Re application no 22/03063/F – Land East of Larsen Rd, Heyford Park

CDC Strategic Housing response to revised proposal September/October 2023

DRAWING NO: 0778-620 HOUSE TYPE REF: SF58/59 TENURE: AFFORDABLE

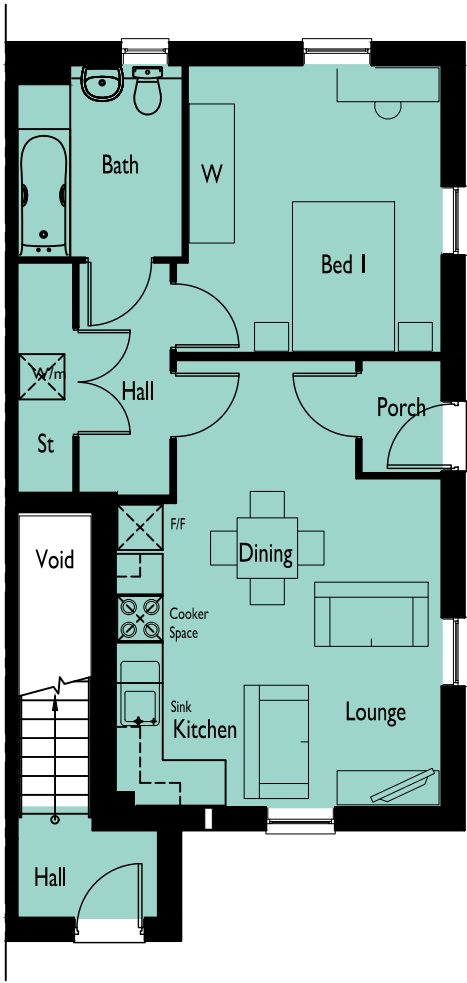
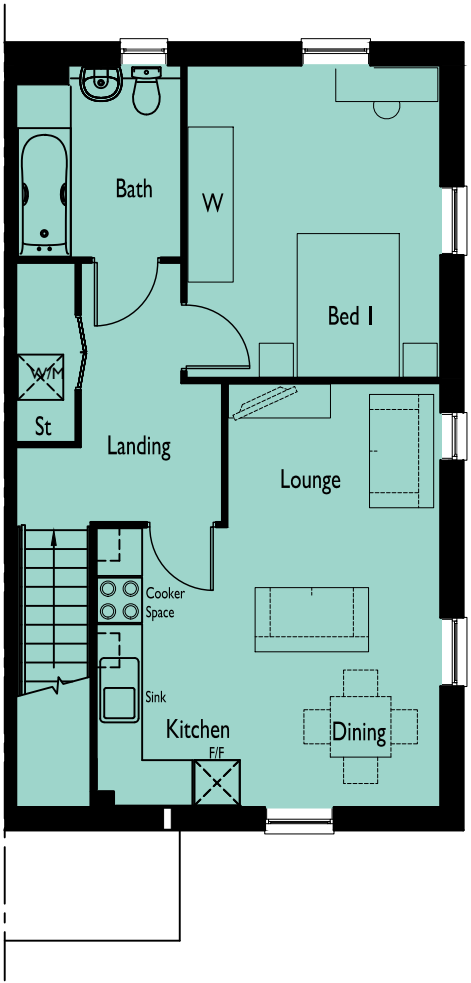
Regarding the proposed dwelling types, we note that the tenure plan states flats rather than maisonettes for the 1-bed provision, however the plans indicate that they are maisonettes. We prefer maisonettes as they provide greater private space, have their own entrance and have the external appearance of houses which enables better integration of tenures. It would be helpful if it could be confirmed that these are maisonettes.
